# A417 Missing Link DCO

Joint Councils Deadline 5 submission

9 March 2022

Document title: Joint Councils Deadline 5 submission

SECTION A-A
SCALE 1:125

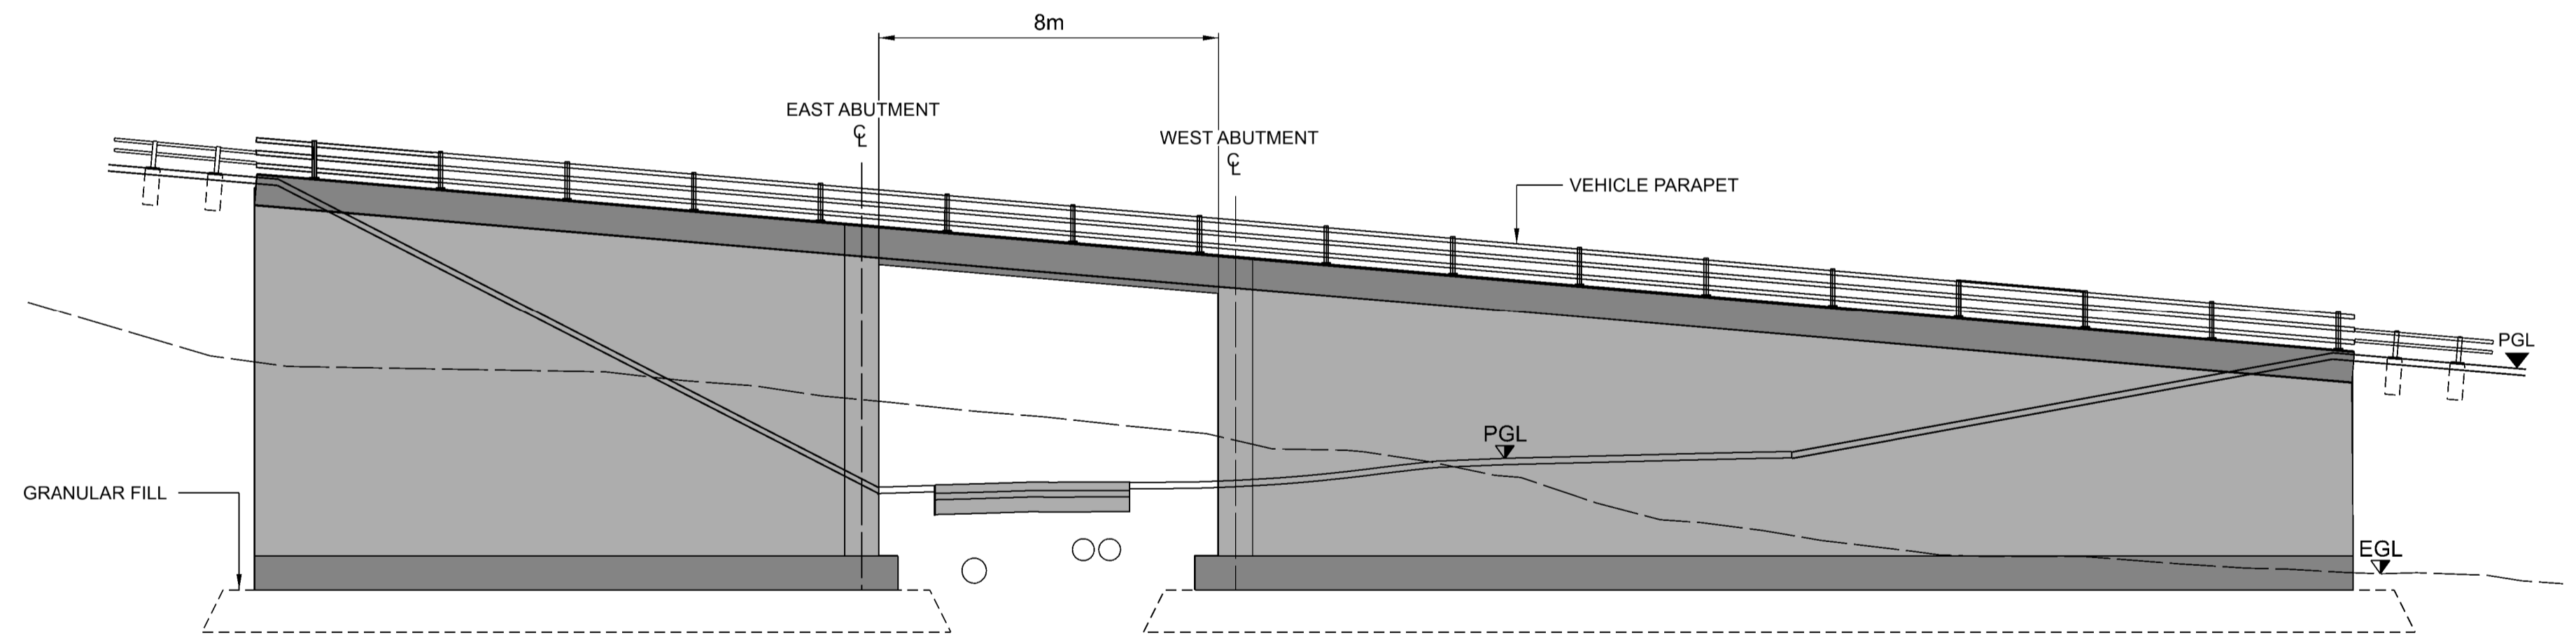
- There should be clear evidence that the structures will make a positive contribution to sense of place
  - There should clear commitments to ensure the Gloucestershire Way Bridge will be engineered to successfully sustain calcareous grassland and hedgerow habitats and that there is a clear long-term management plan for this structure

- There should be clear evidence that the suite of bridges – Gloucestershire Way bridge, Stockwell bridge and Cowley bridge will provide both human and wildlife connectivity. We are still concerned that these structures will not provide the necessary landscape connectivity nor be engineered to sustain habitats (whether hedgerows and trees on Stockwell and Cowley, or full habitat creation on Gloucestershire Way bridge).
